**FINAL DRAINAGE REPORT
FOR
SADDLEHORN RANCH – FILING 5 EARLY GRADING**

**August 17, 2023
Project No. 25142.07**

**El Paso County PCD File No.:
EGP226**

SADDLEHORN FILING 5 EARLY GRADING PROPOSED DRAINAGE MAP

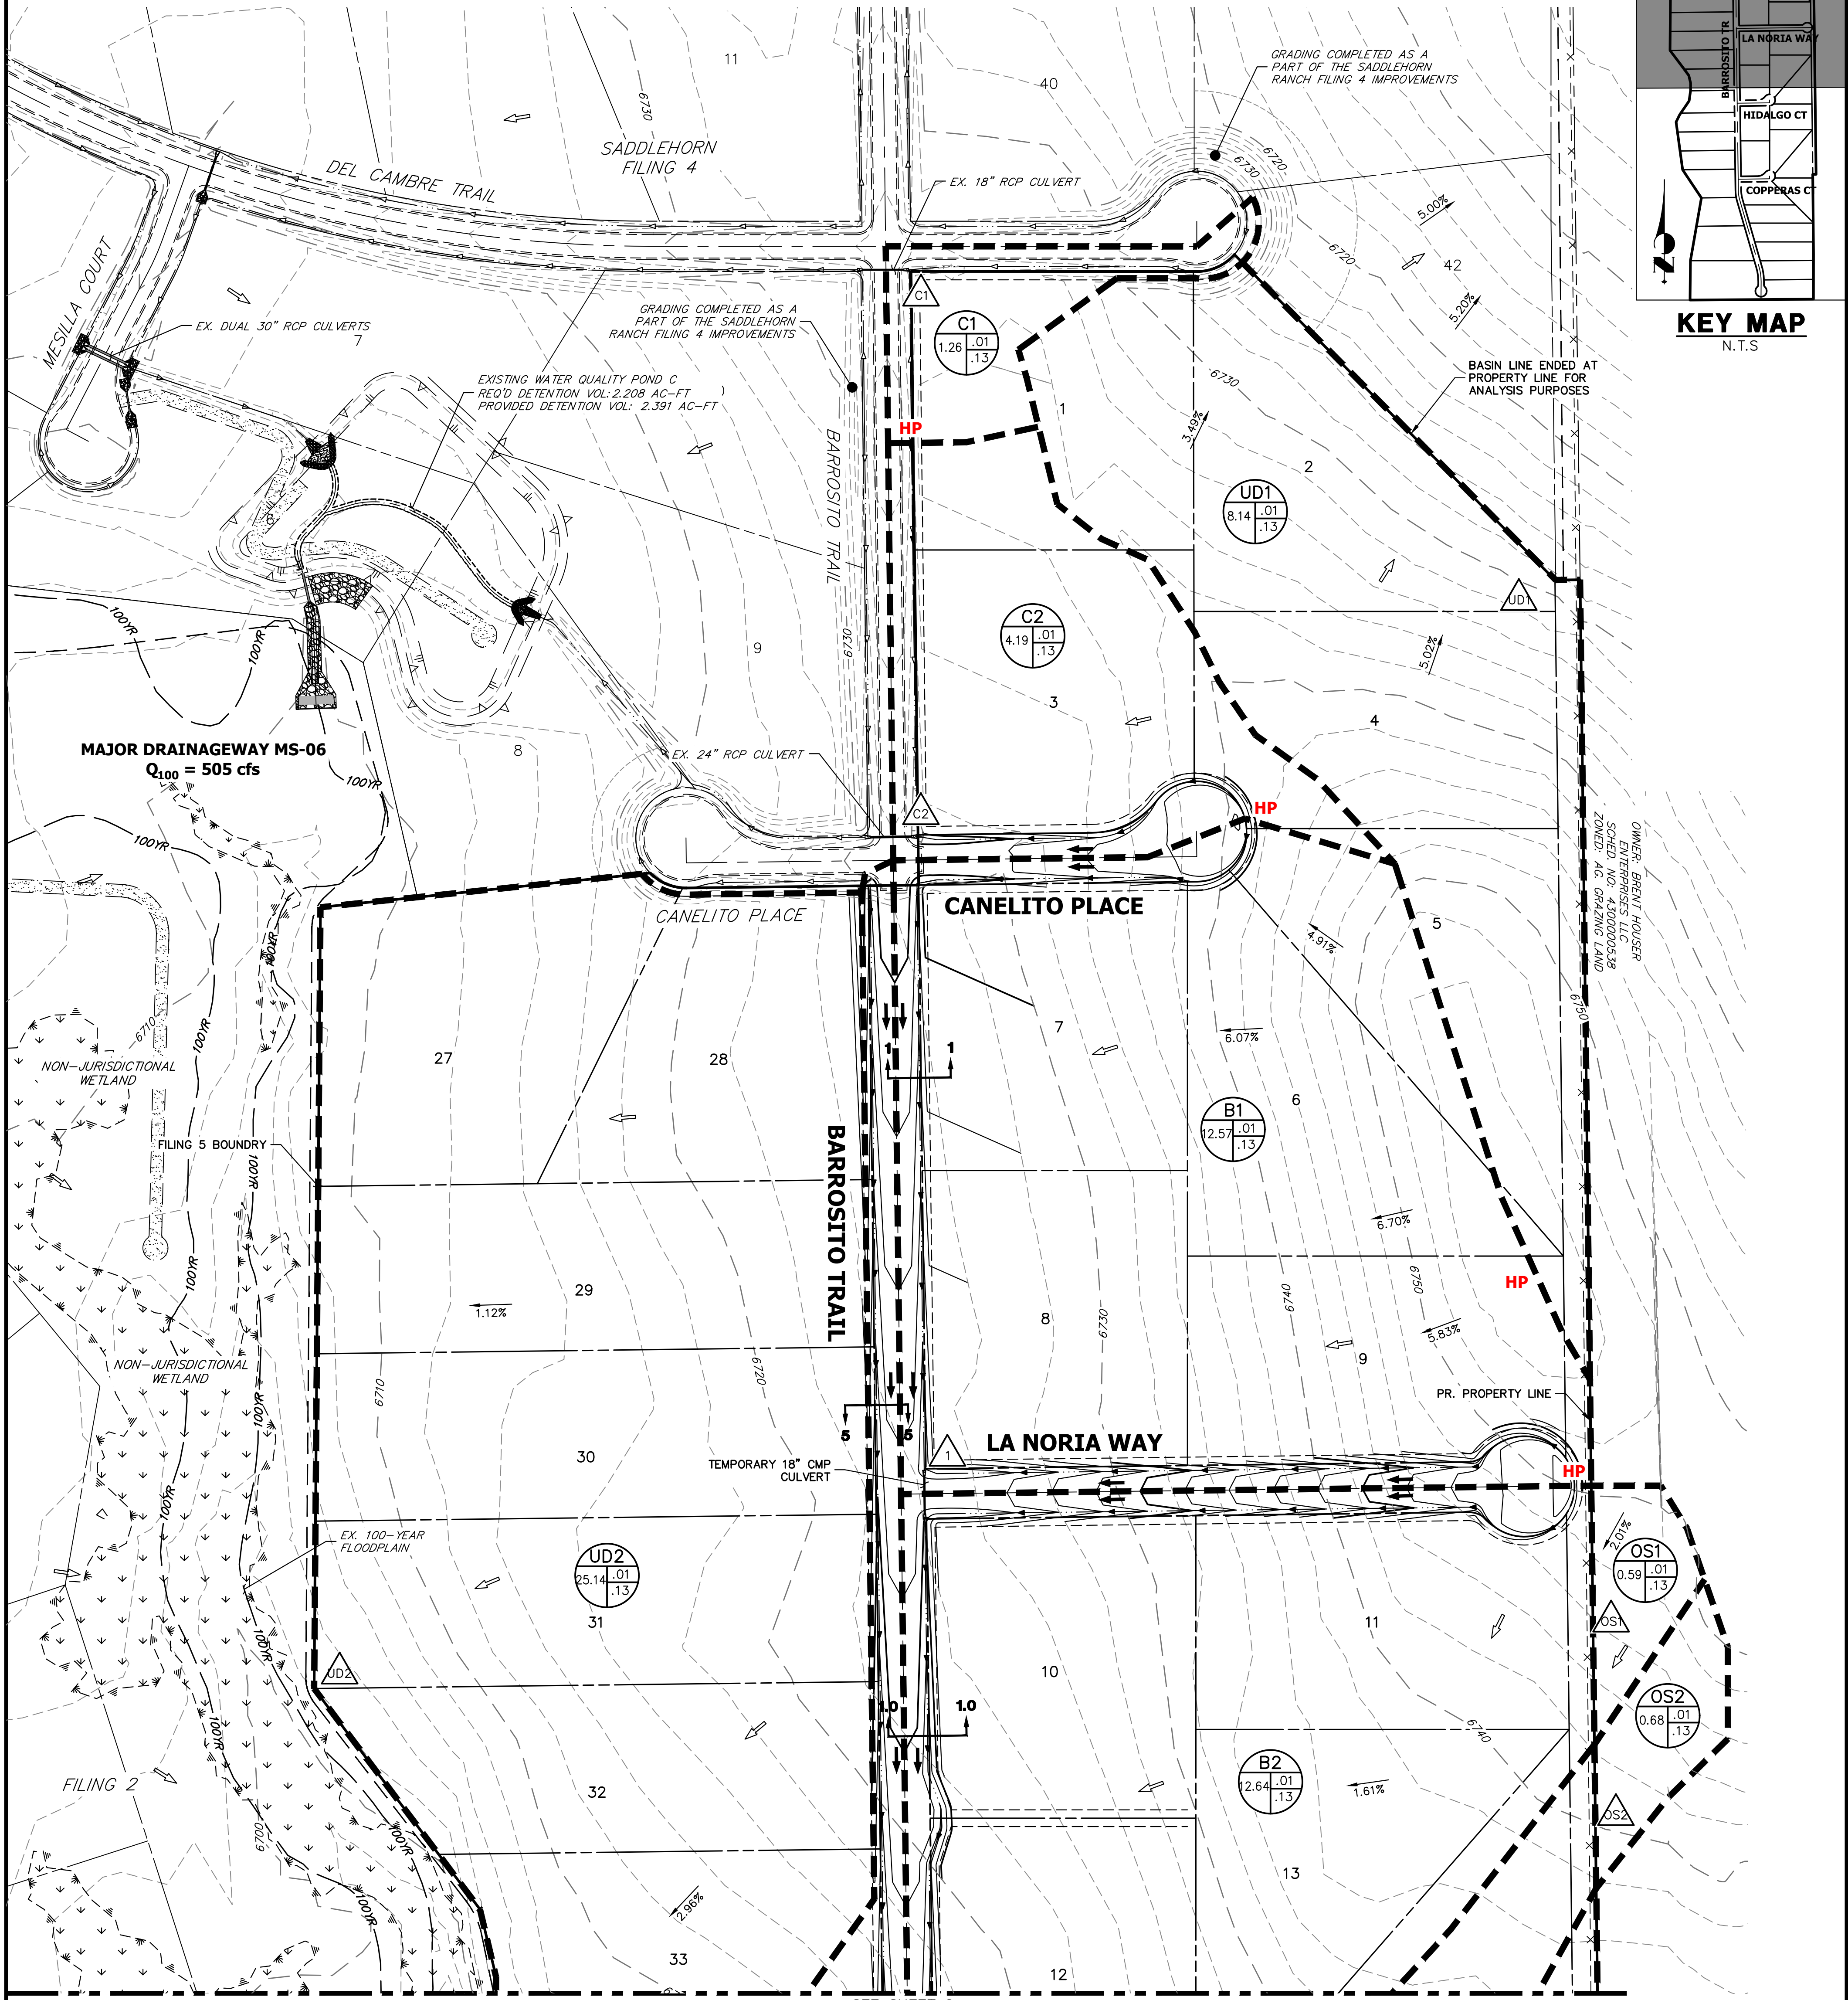
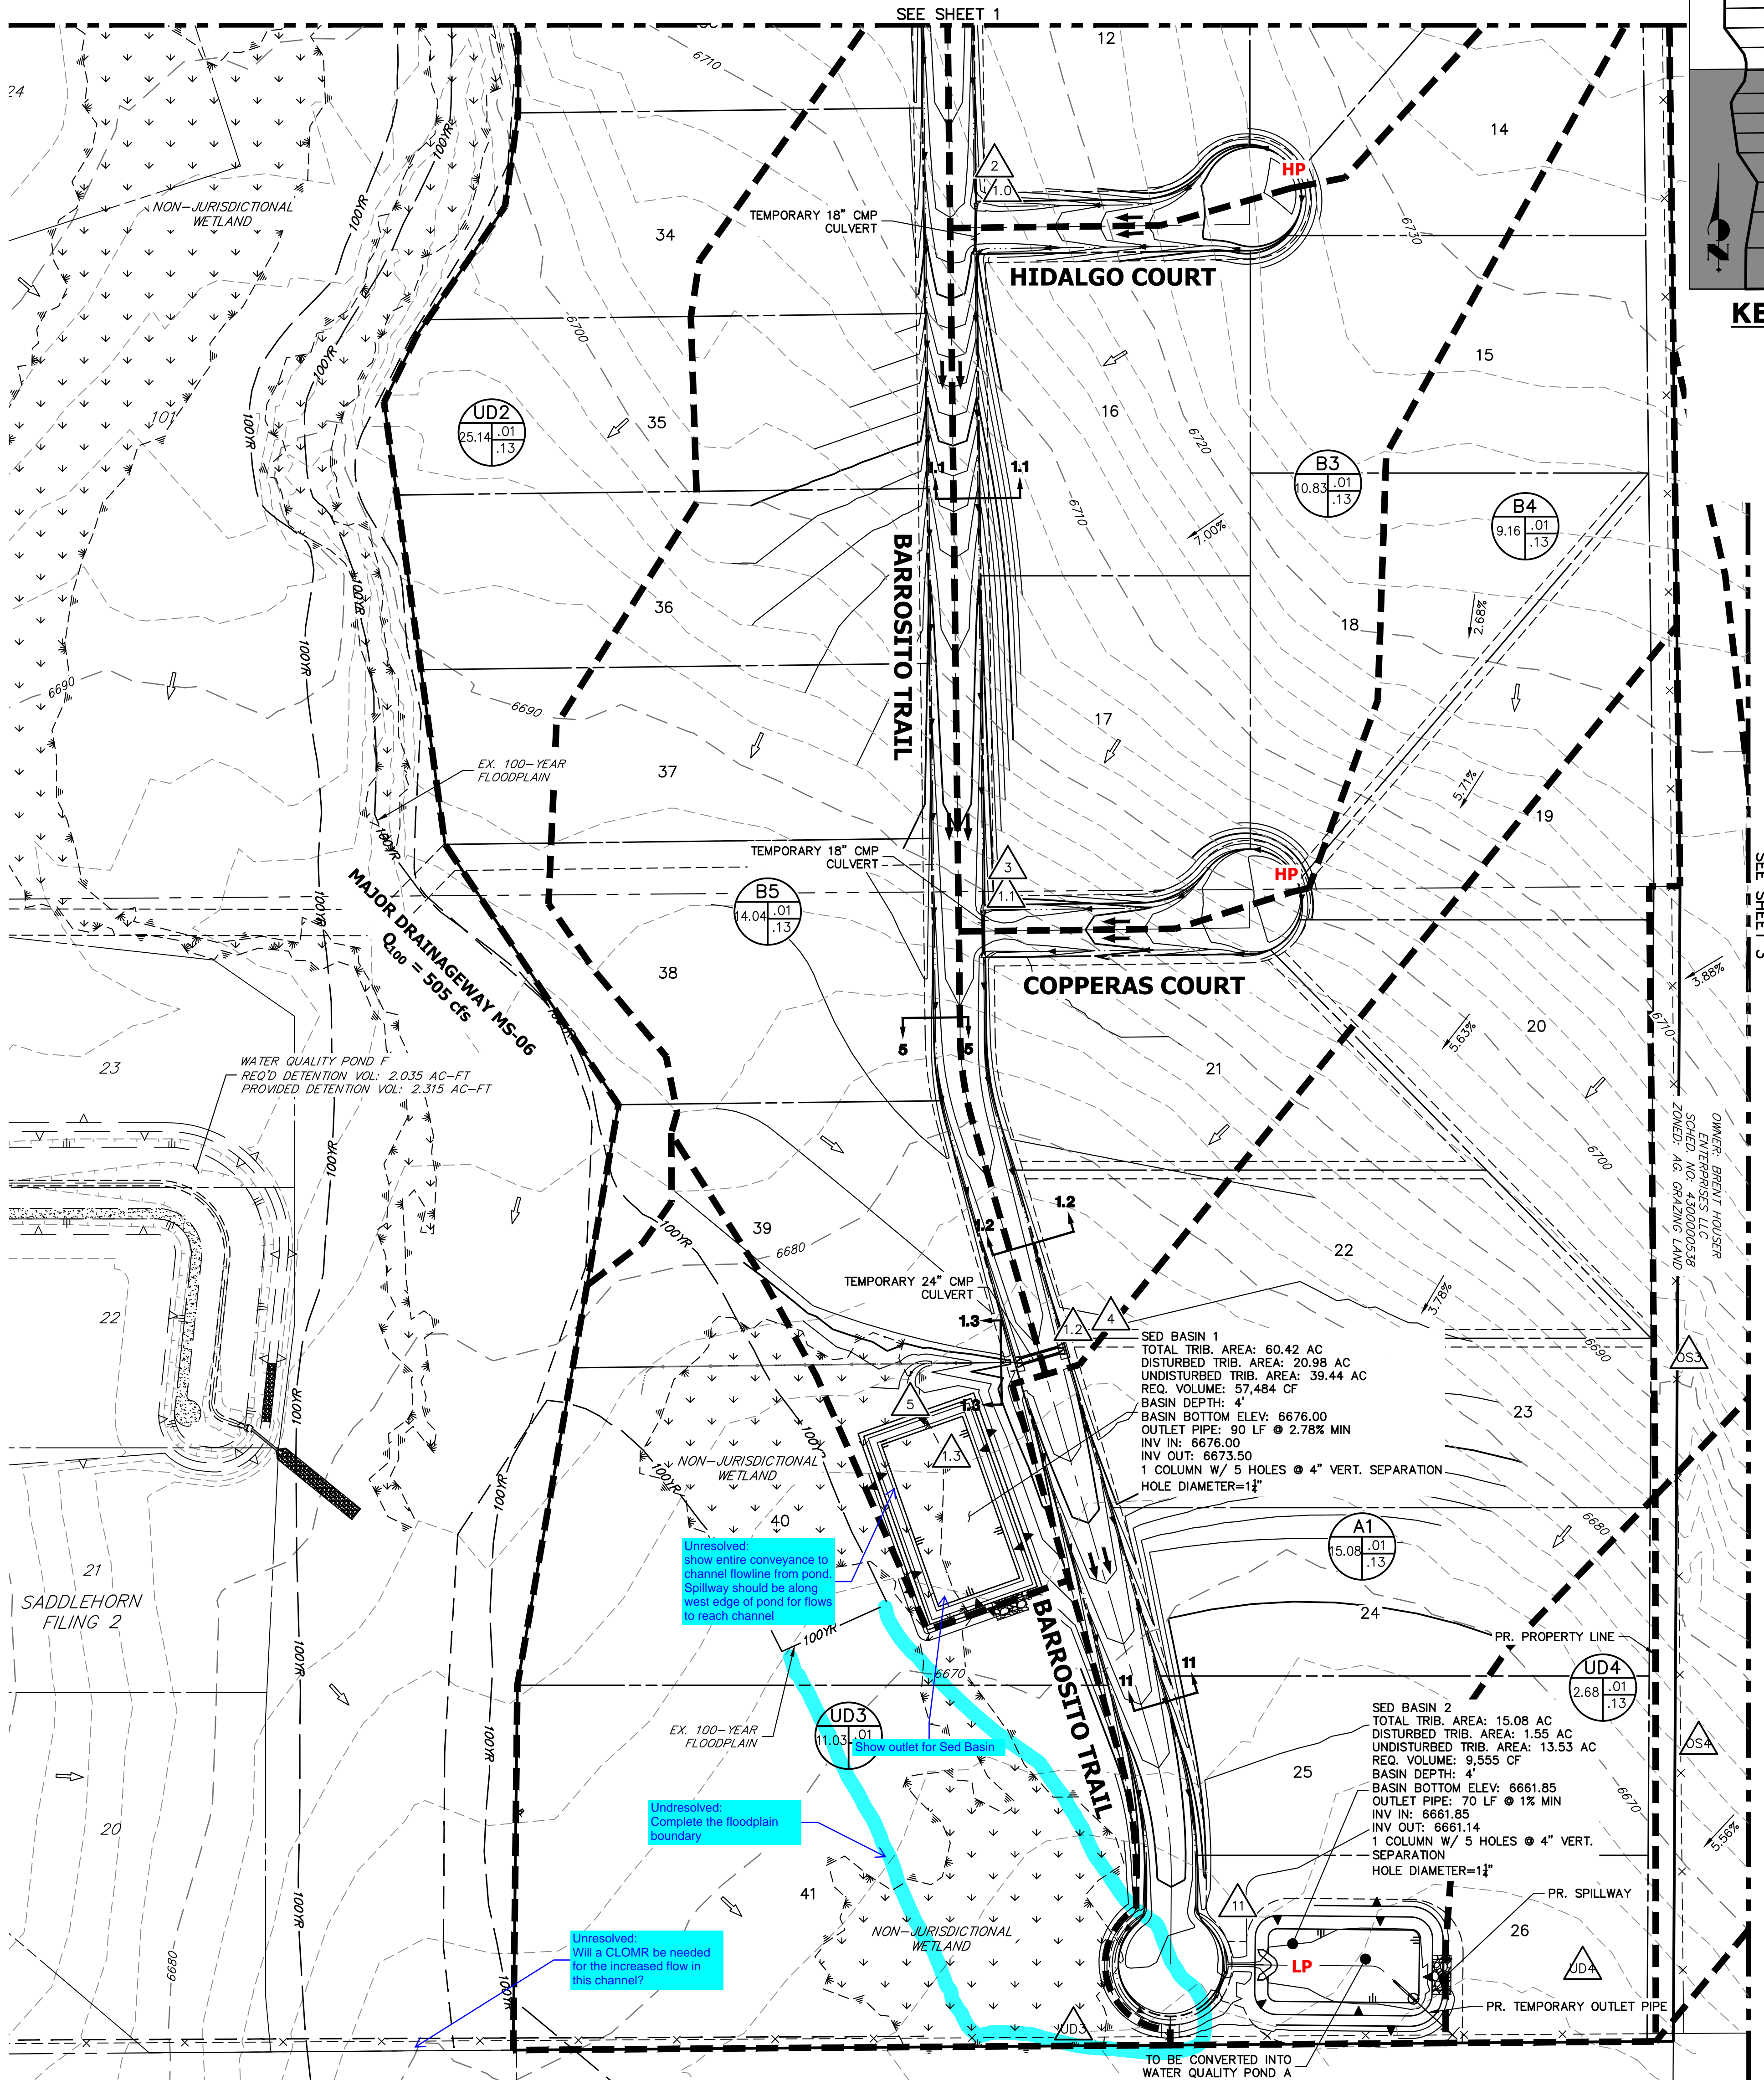
59.24 for Basins B1 to B5. Does this include OS1 & OS2? then include them in the discussion that OS1 & OS2 are also diverted to Sed Pond 1

Finish basin name
